M25 junction 10/A3 Wisley interchange TR010030 8.3 Statement of Common Ground with Environment Agency

8.3 STATEMENT OF COMMON GROUND WITH ENVIRONMENT AGENCY

Version	Date	Status of Version
Rev 2	3 March 2020	Deadline 5
Rev 1	28 January 2020	Deadline 3
Rev 0	June 2019	Development Consent Order application

9.21 Scheme Layout Plans Annotated with Works Numbers (Reference 1.1.4 ExQ1)

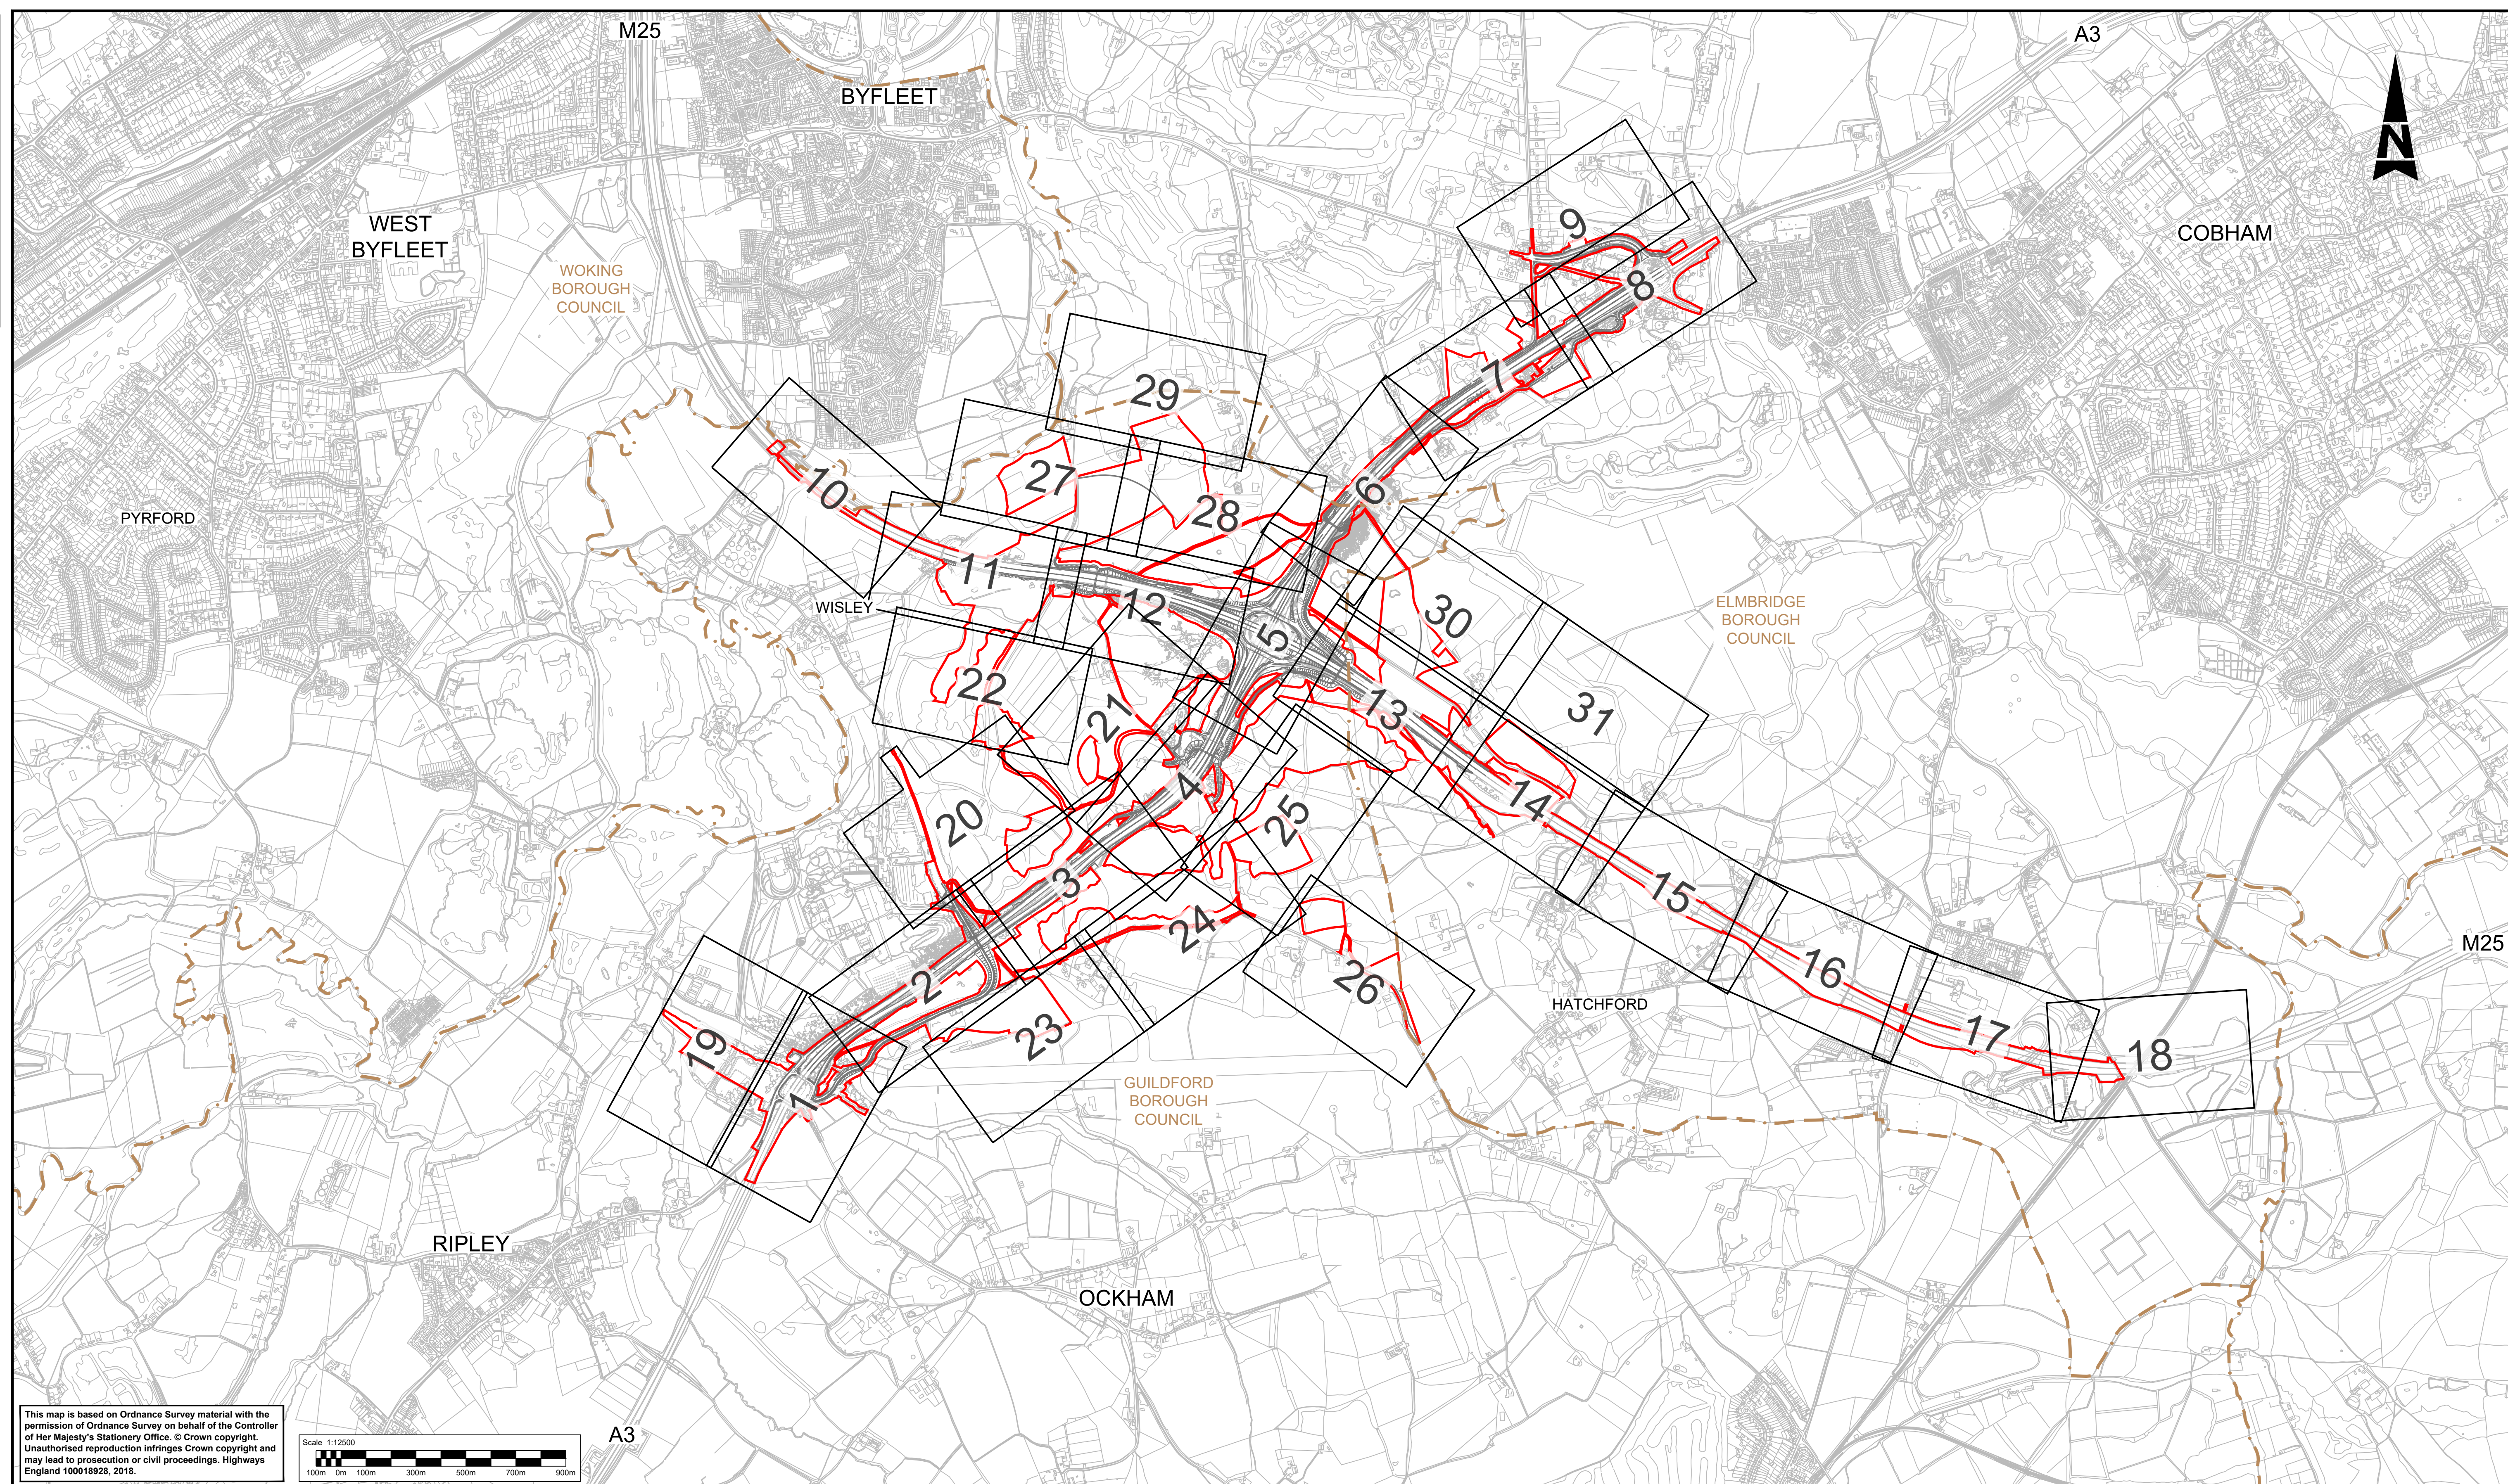
3.1.6	WFD Assessment Comments Log (CL): 028	Stratford Brook Crossing	Paragraph 5.4.3 of the WFD report states that “the bridge deck should run perpendicular to the watercourse (to reduce shading)”. The EA are	The planform of Stratford Brook at the New Stratford Brook Underbridge is shown on Sheet 1 of the Scheme Layout Plans	Agreed

Issue	Sub-section	Environment Agency Comment	Highways England Response	Status
			<p>concerned that the bridge deck isn't running perpendicular to the watercourse and that this could necessitate the need for bed and bank reinforcement later down the line. Highways England should provide justification for this alignment.</p>	<p>[APP-012]. Structural details for the bridge are provided on page 57 of Engineering Drawings and Section [APP-014]. The bridge crosses a sinuous reach of the brook. Fitting this multi-curve meander shape into the rectangular shape of a bridge is a challenge that has principally been addressed by designing a bridge with a very wide span. The abutments of the span are broadly parallel with the most likely (downstream) progression of the meander under the bridge, lowering the risk of the river making contact with the bridge into the future. The design represents a sensible balance between accommodating the needs of the water environment with the alignment and constructability of the road. The EA were satisfied with this justification for the alignment of this bridge at a meeting on 08 October 2019 (A.43).</p>

Issue	Sub-section	Environment Agency Comment	Highways England Response	Status
			<p>bridge deck so that it's perpendicular to the watercourse.</p>	<p>Highway's England will review the means by which amendments to the WFD can be made during the DCO process if considered necessary. Suggested rewording to "bed and bank protection should only be used where an erosion hazard cannot be avoided (for instance by relocating an abutment or pier) and a real risk to life or critical infrastructure is apparent". The EA were satisfied with this justification at a meeting on 08 October 2019 (A.41).</p>
